PLAN REVIEW SHEET

Date: July 27, 2023

Petition #: 2023-036

RZ-2

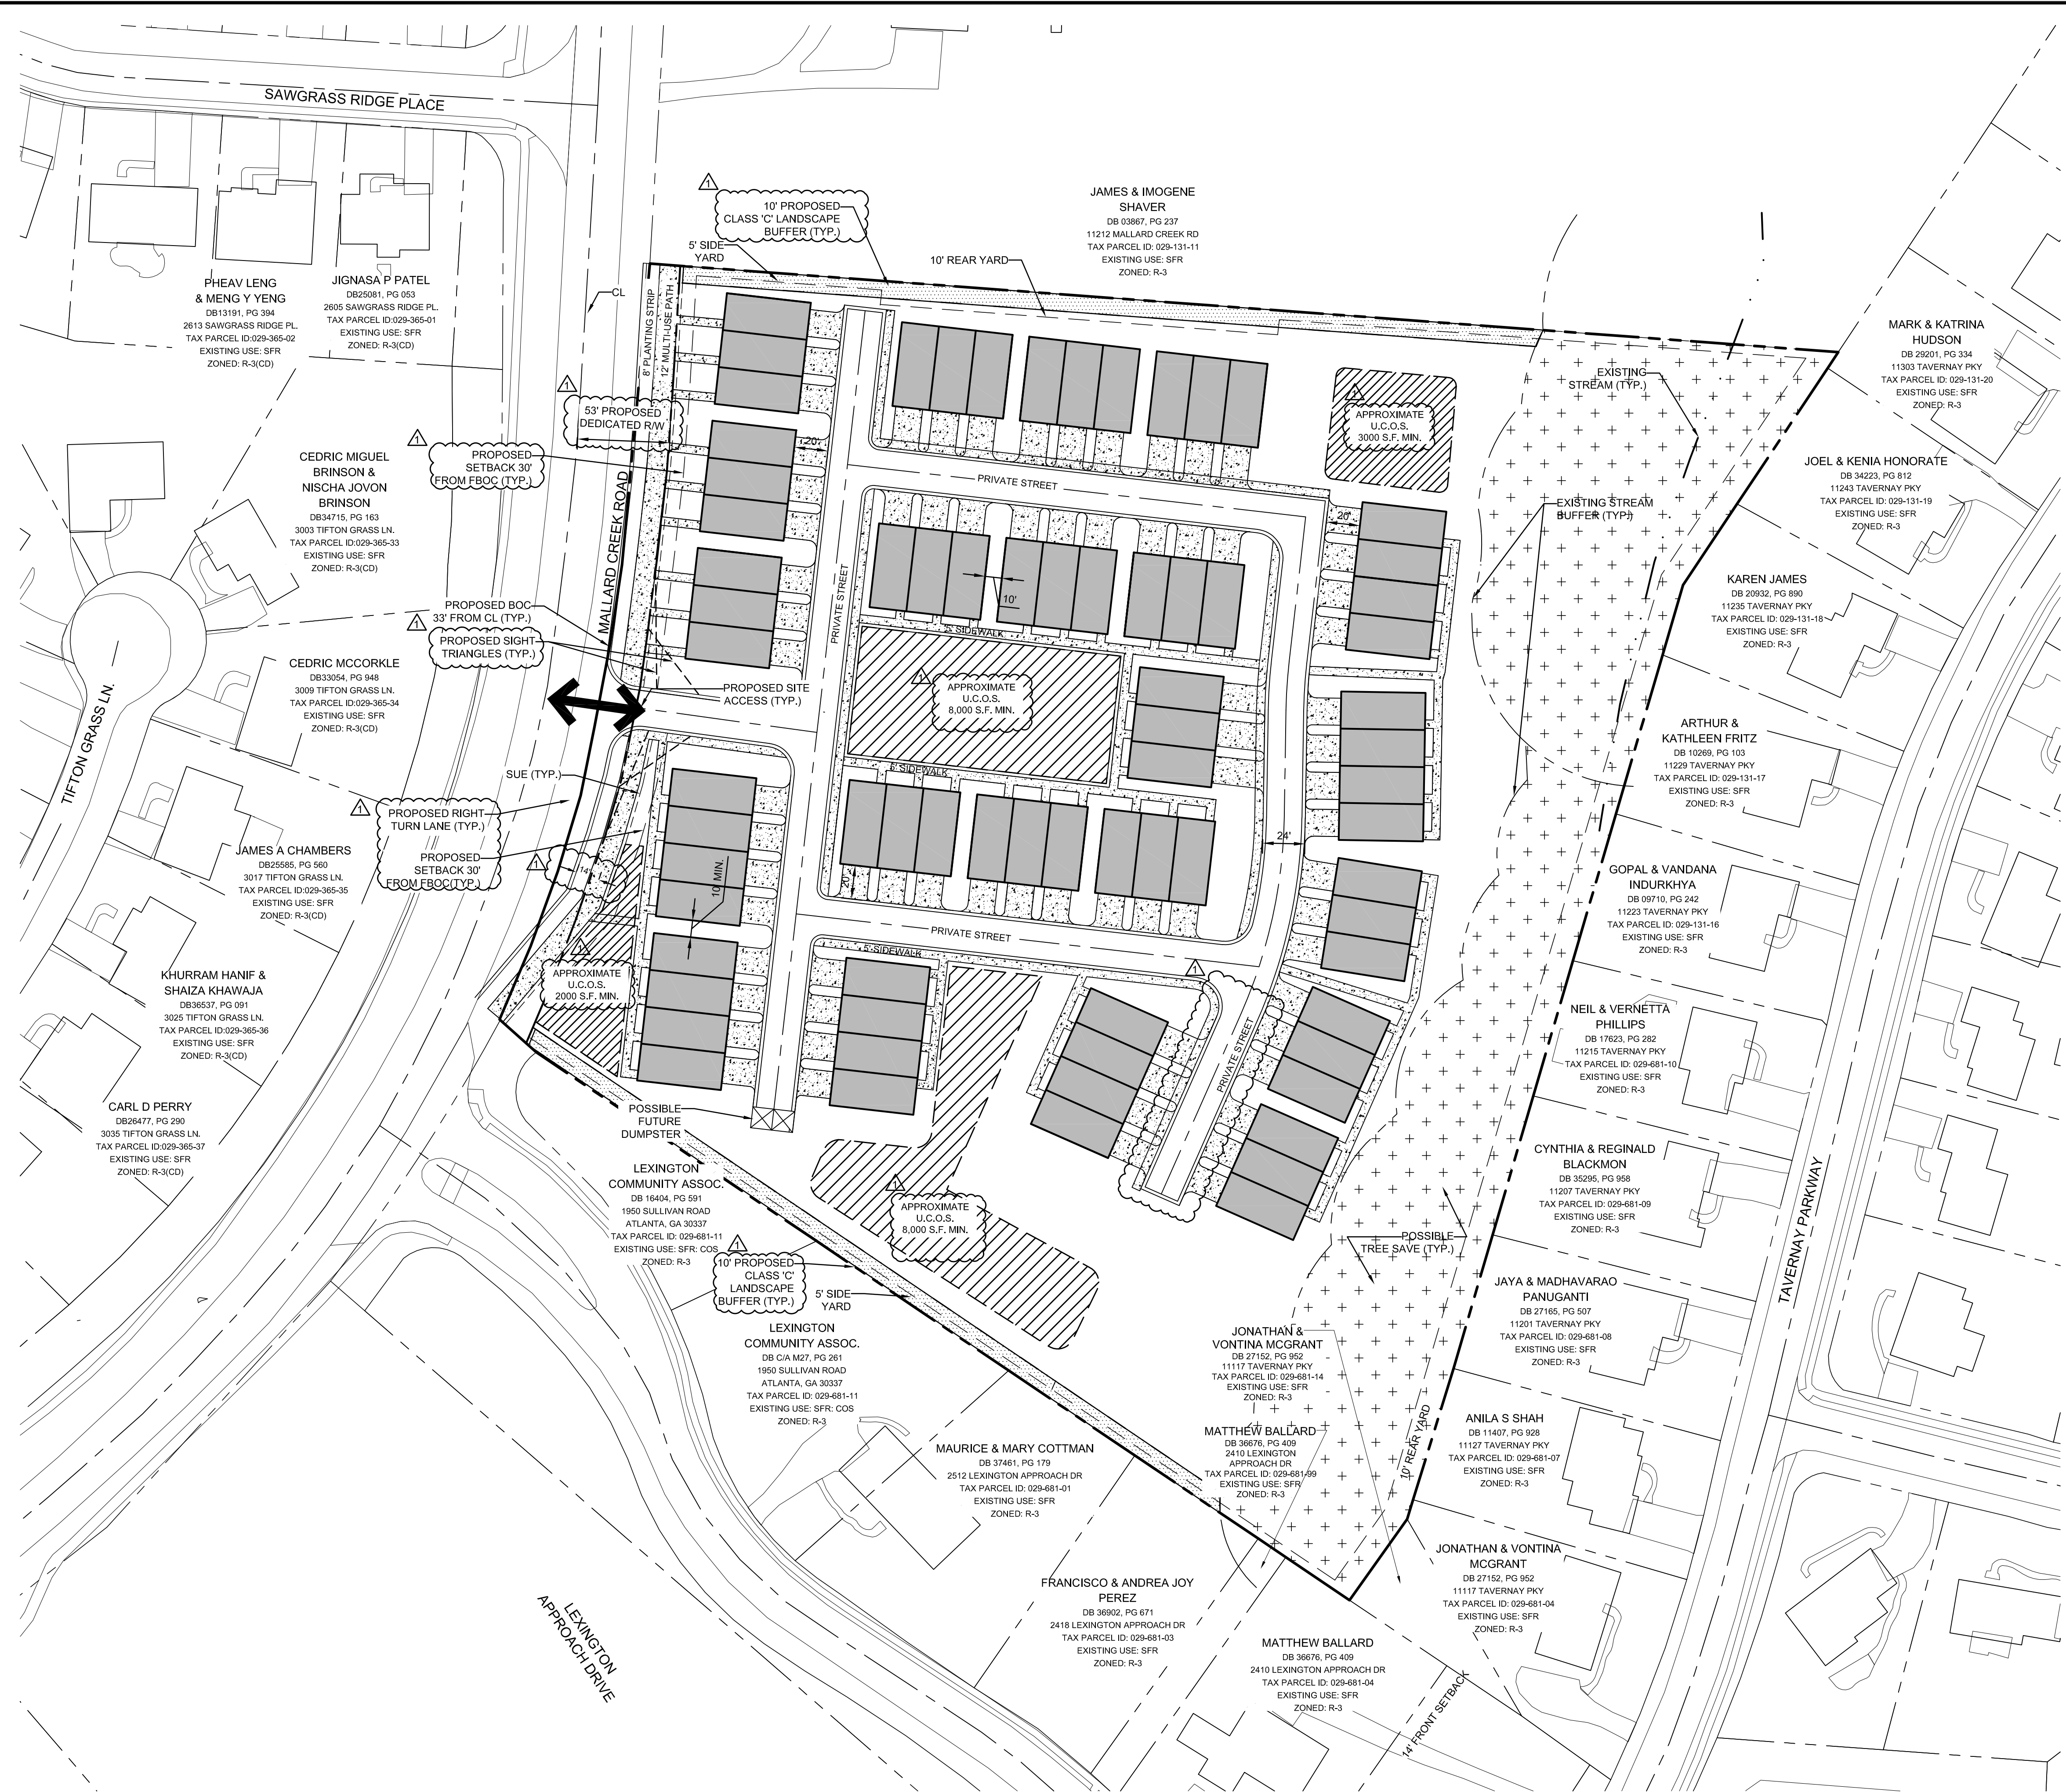
The site is located at 11128 Mallard Creek Road and served by CATS bus route #54. CATS requests the construction of ADA compliant bus standard detail 60.02A, 50 feet beyond the development entrance. The final location will be coordinated with the developer during the Land Development plan review process.
